Arun District Council
Arun Civic Centre
Maltravers Road
Littlehampton
West Sussex BN17 5LF
Planning & Building Control General Enquiries
Tel: (01903) 737756 Fax: (01903) 730442
Dx: 57406 Littlehampton
Minicom: 01903 732765
e-mail: planning@arun.gov.uk
website: www.arun.gov.uk/planning

Application No: A/3/21/PL
Site Address: Pound Place Roundstone Lane Angmering BN16 4AL
Description of works: Erection of a 74-bed care home (C2 residential institution) with car parking, landscaped gardens & access from Roundstone Lane. (resubmission following A/9/19/PL). This site is in CIL Zone 2 (Zero Rated) as other development.

Thank you for your internet representation made on 8th February 2021 which has been recorded as support with the comments as follows:

Drawing Site Layout
General Arrangement

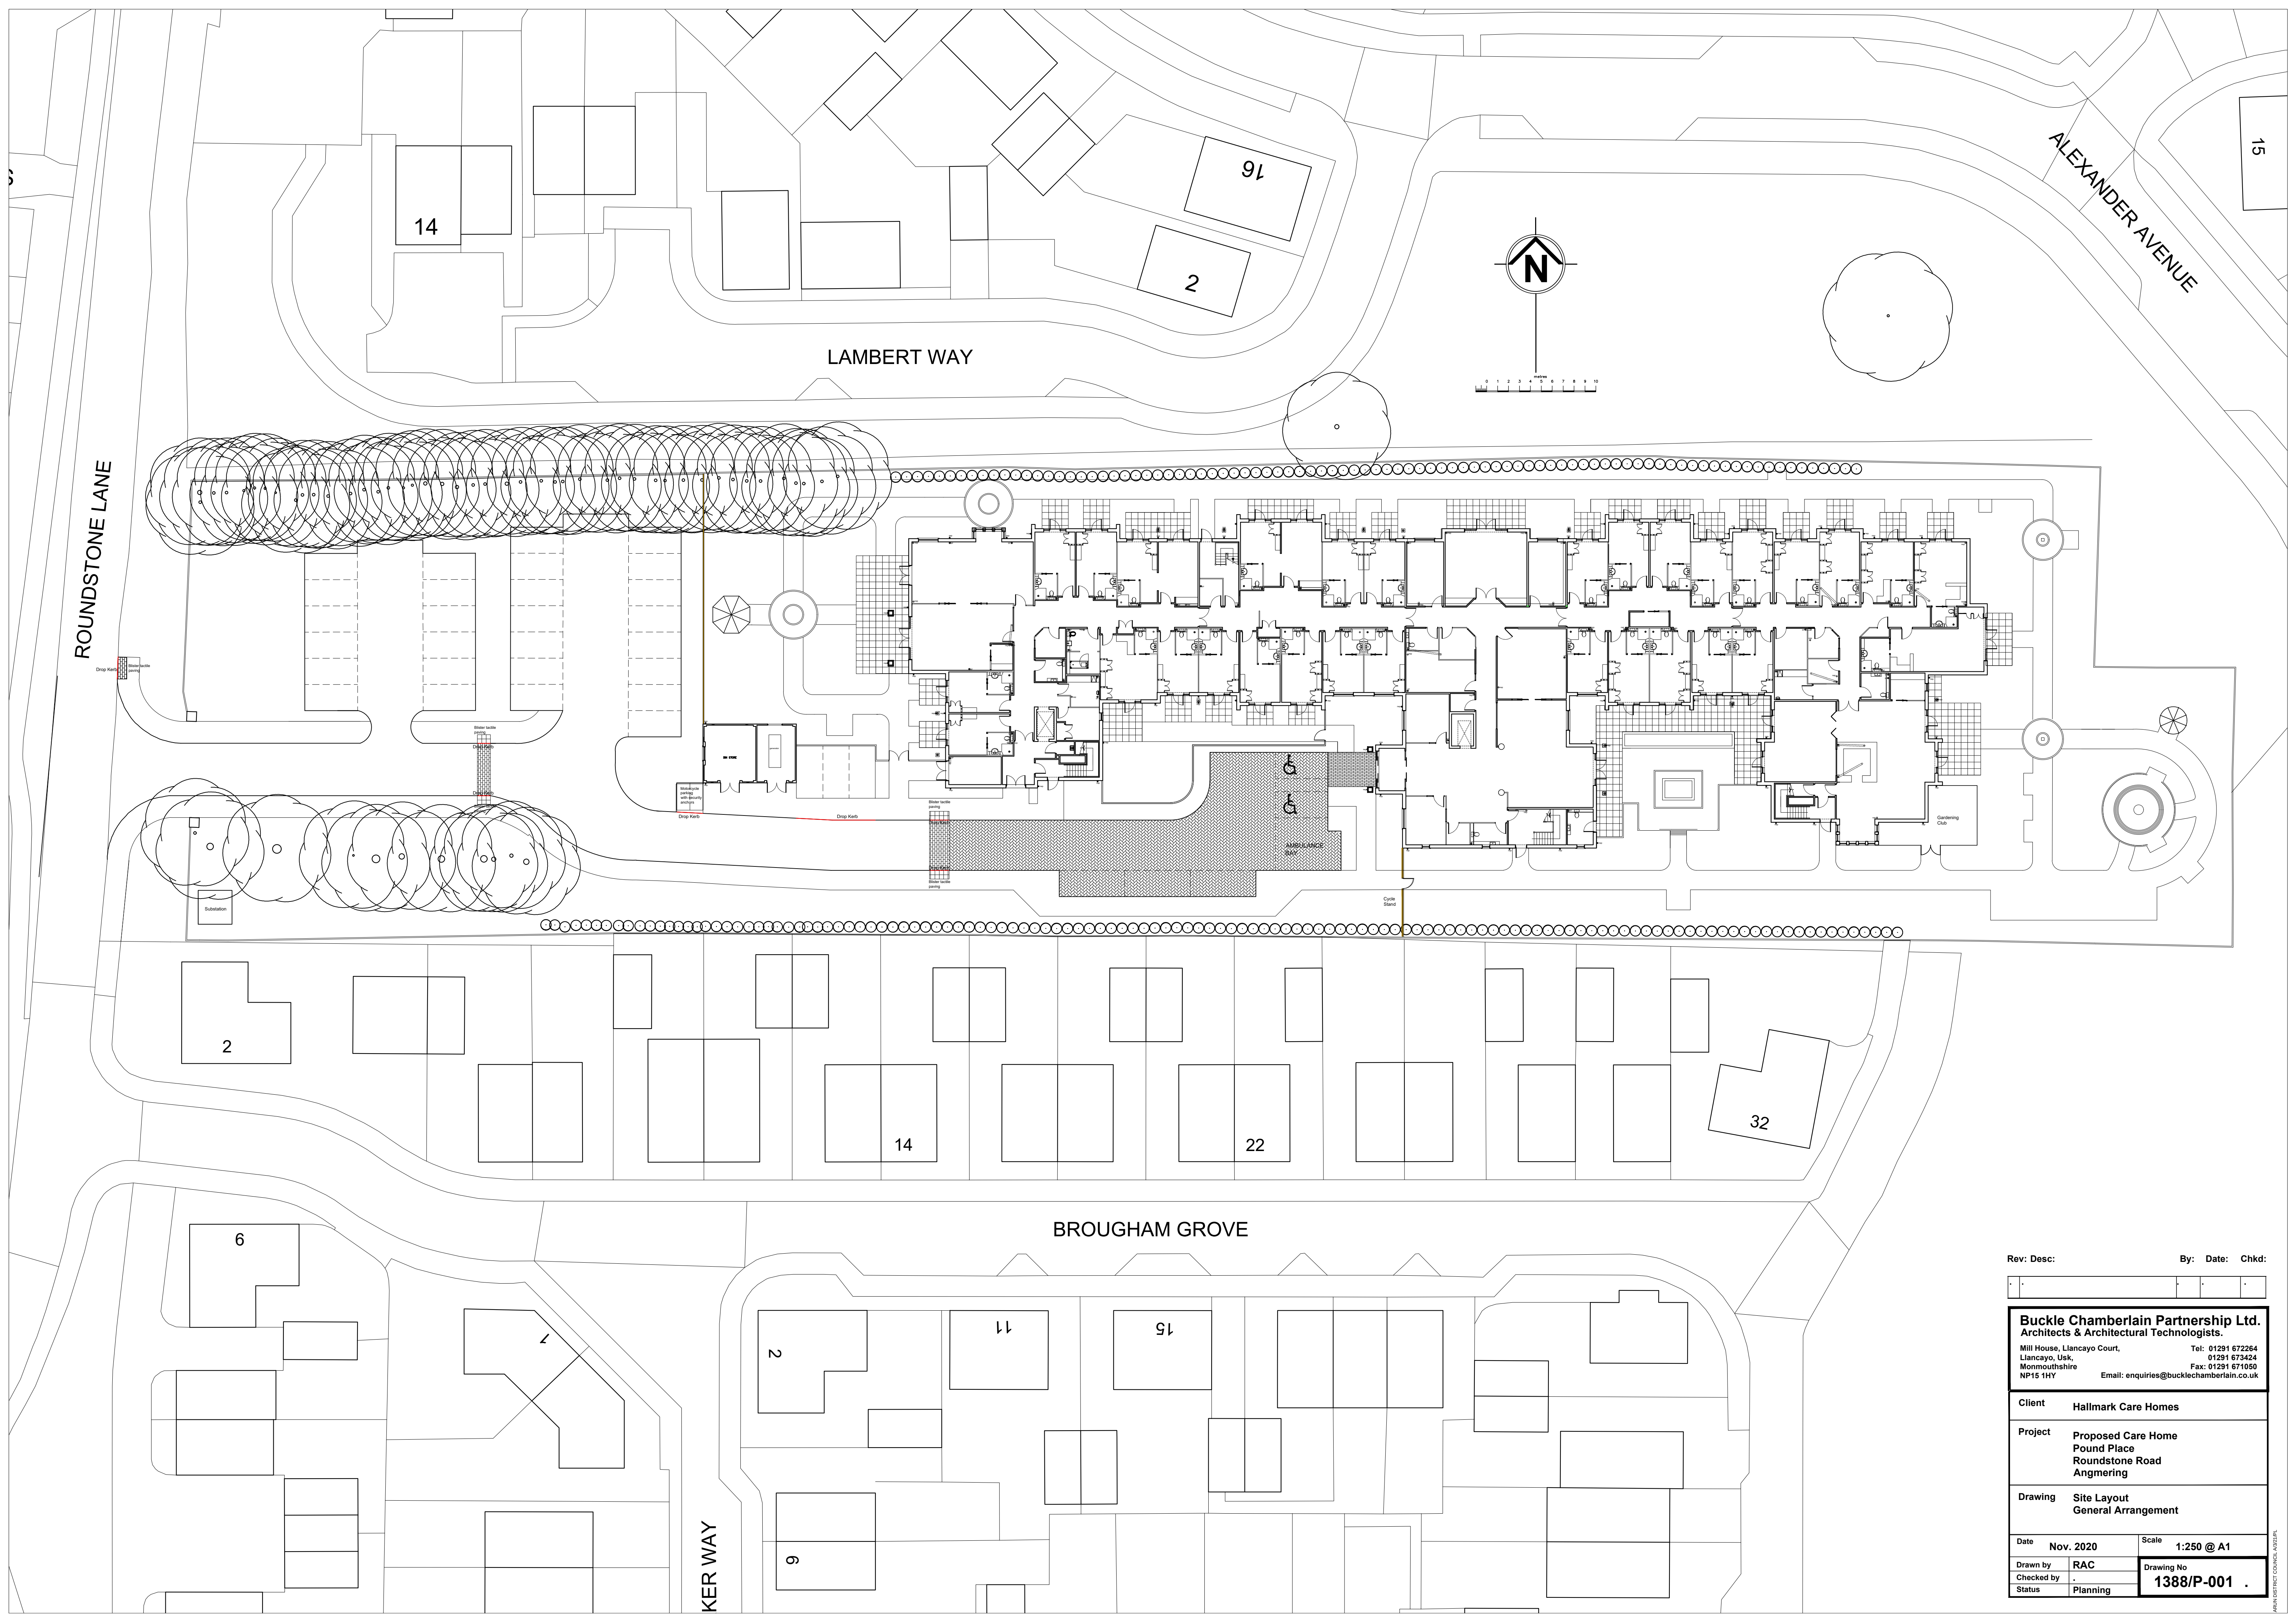
I have no objections in principle to the proposed internal alterations. However, I feel that the additional provision of just 3 extra car parking spaces is inadequate. Currently construction workers have parking provided within the Rugby Club but there is still a spill over onto local roads, most notably on the junction with Nursery Road. There is an infrequent bus service that serves Roundstone Lane which is unlikely to be of significant use to staff employed once the care home is completed. Therefore more car parking spaces are already required and the provision of 10 further bedrooms for residents will add to this figure as well as visitors attending. I would also make the case for improved landscaping to the car park area so as to 'shield' the car park visually from Roundstone Lane.
